From: Laura Gibbons
Sent: 20 December 2018 11:56
To: Planning.Responses
Subject: RE: Planning Consultation on Y/92/18/DOC

Engineers Comments Regarding Conditions 8, 9 and 10

APPLICATION NO: Y/92/18/DOC

Site Address: Land at Long Acre Maypole Lane Yapton

5.007	Swale	500	217		S62	8.14	9.14	0.50	S63	7.84	8.84	0.50
5.008	Swale	500	348		S63	7.84	8.84	0.50	S63_OUT	7.77	8.77	0.50

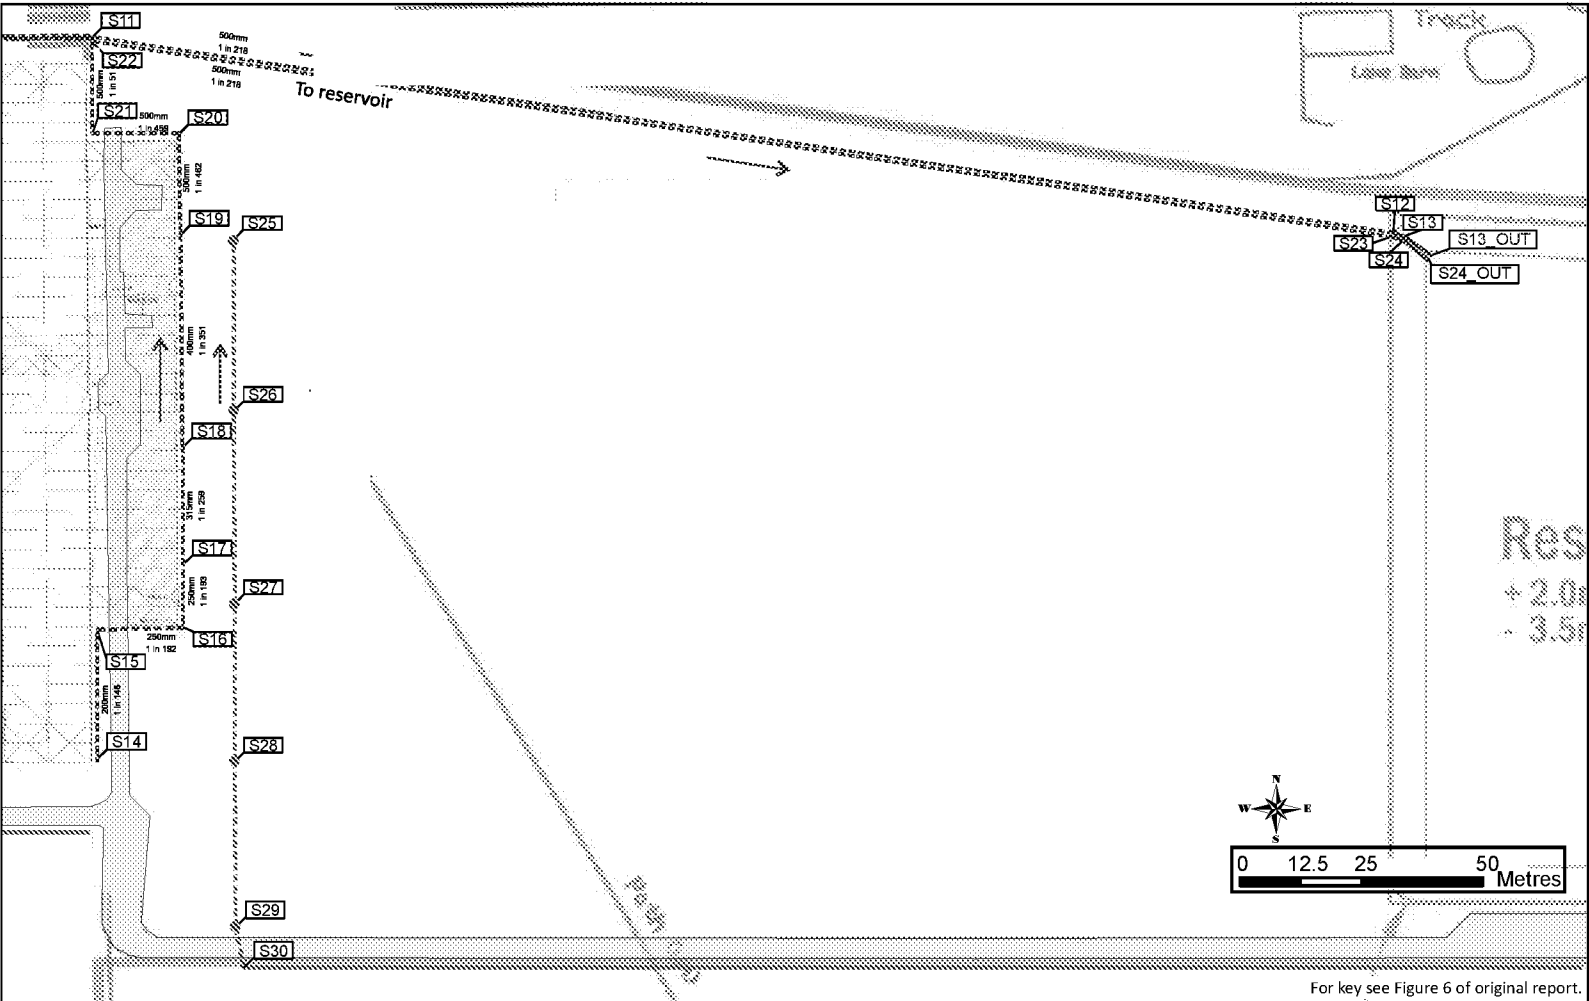
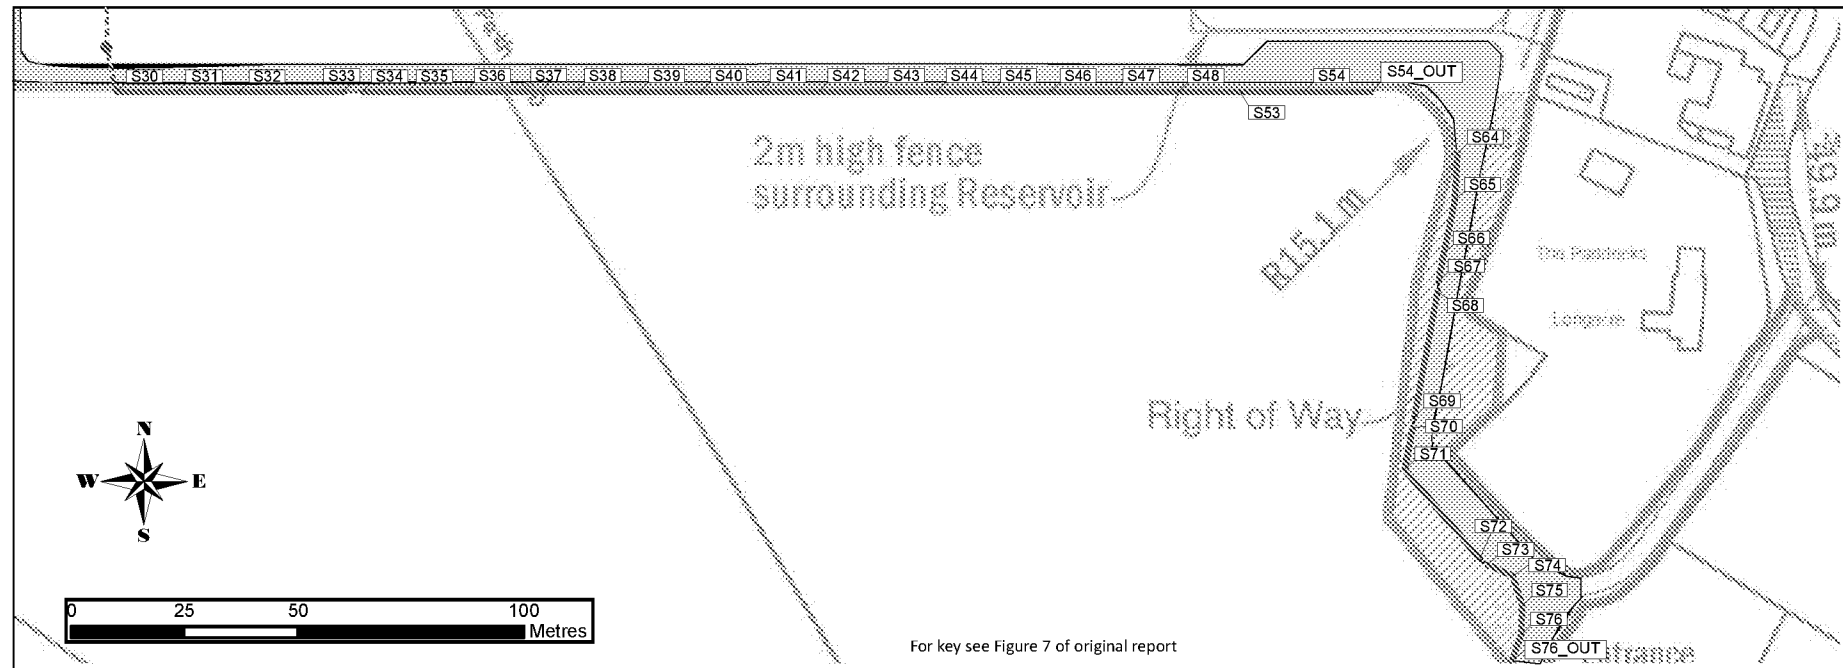
13. Layout plans need to show: slopes, diameters and materials of pipes; cover levels and invert levels of all manholes and silt traps; base levels and bank levels of all swales; overflow levels; etc. I.e. they need to be of a construction standard.

L-Bloc® / 1.2m / Reinforced

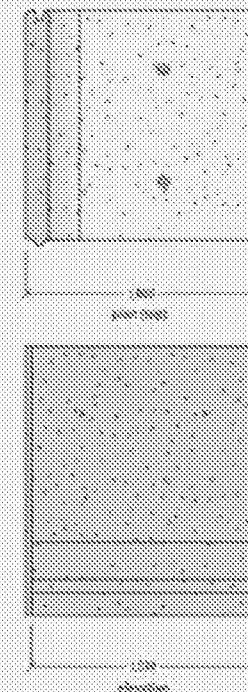
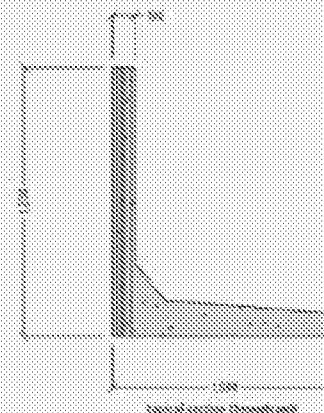
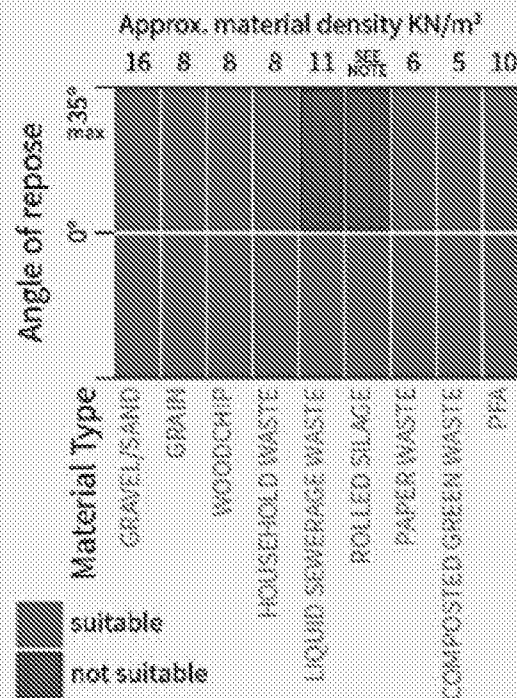
10. Can you also select to just print results from the critical storm events, to reduce size.
11. Please provide exceedance flow routes.
12. Please provide further details of the flood risk barrier.
